Planning Application Ref: BR/138/18/DOC

Location: Villa Maria, Campbell Road, Bognor Regis

Description of works: Application for approval of details reserved by conditions imposed on planning reference BR/270/16/PL relating to condition no. 3 (Drainage), **4 (Arboricultural Protection Measures)** & 6 (Materials & Finishes)

Project:-	Proposed Conversion Villa Maria Campbell Road Bognor Regis		
Title:-	Proposed Tree Works		
Client:-	SCG Properties Ltd		
Scale:-	1:100 (@A1)		
Drawn By:-	PJD	Checked By:-	
Date:-	18/07/17	Date:-	
Job.No:-	160035	Drg.No:-	24

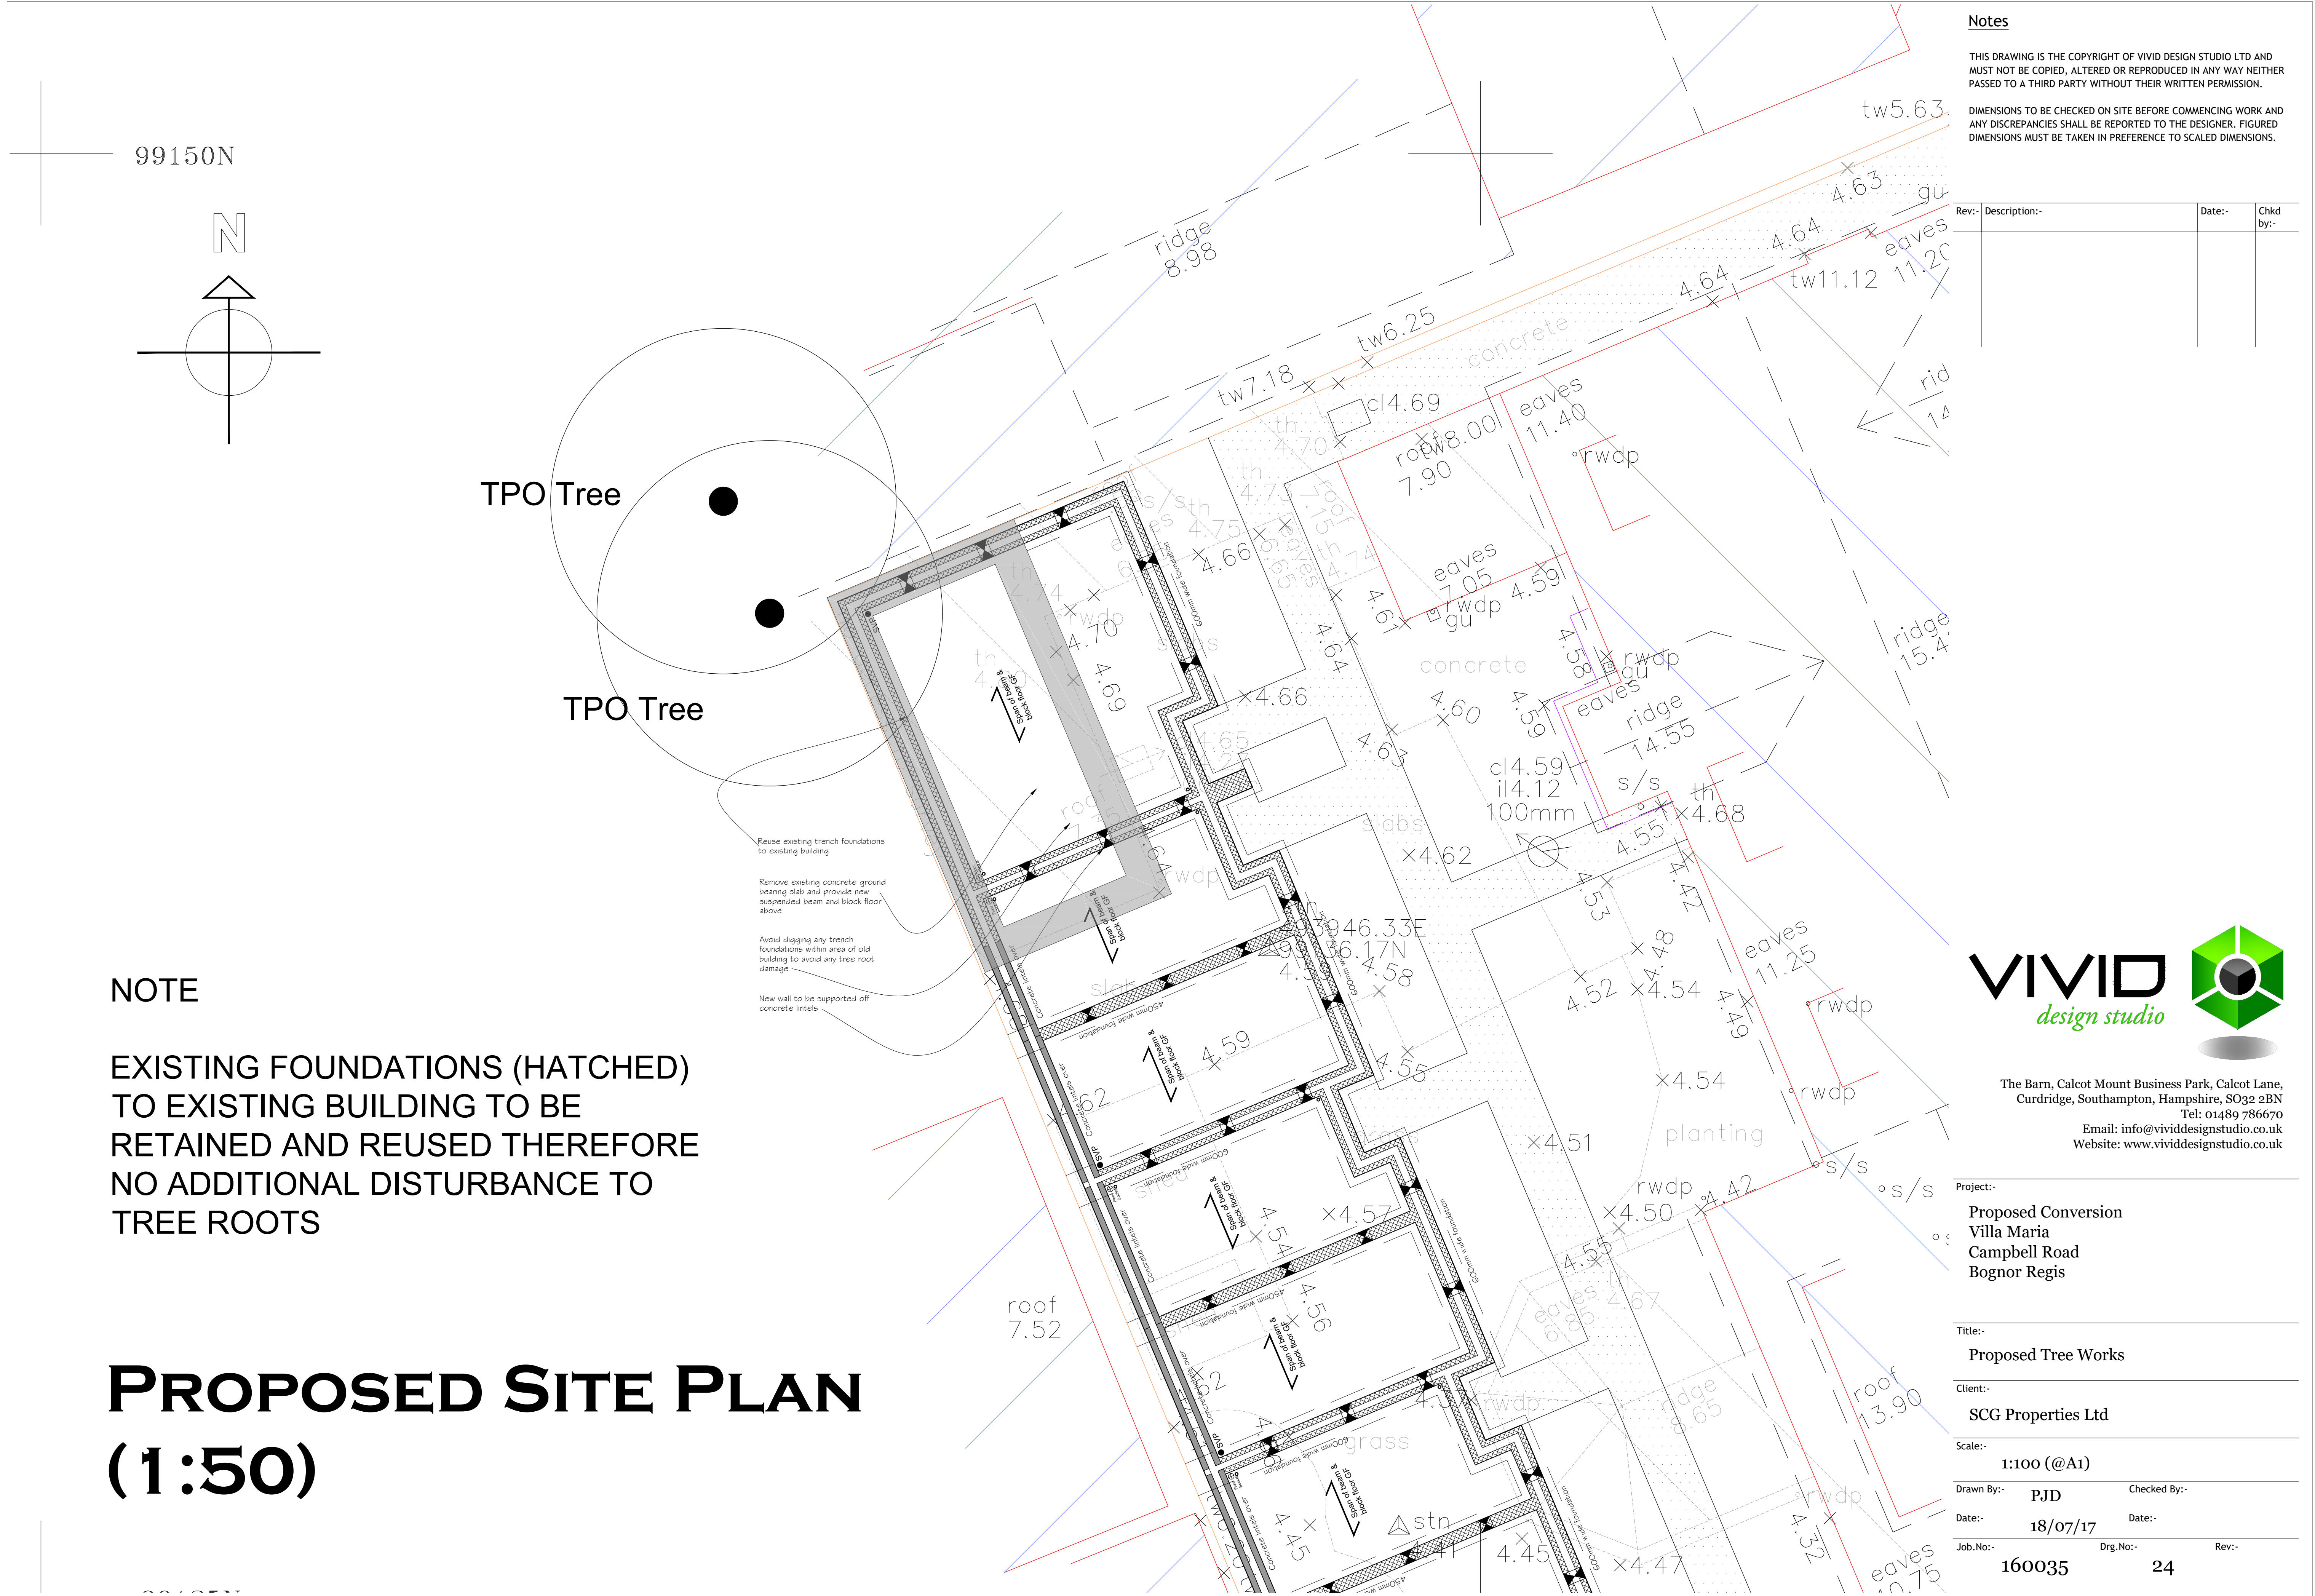
- The apparent late submission of the Arb. report, in any event does not wholly satisfy previous concerns relating to methodology, timing and supervision of works within the assumed Root Protection Area of off-site trees (the subject of an Order) at the NW corner of the site; so does not comprehensively evidence those trees having been afforded the necessary level of respect and protection.
- While there is a possibility that work within the RPA has been undertaken in a satisfactory manner I cannot be confident that this has been the case, so am not in a position to recommend we 'sign off' on this condition.

- I am unable to recommend we 'sign off' this condition.
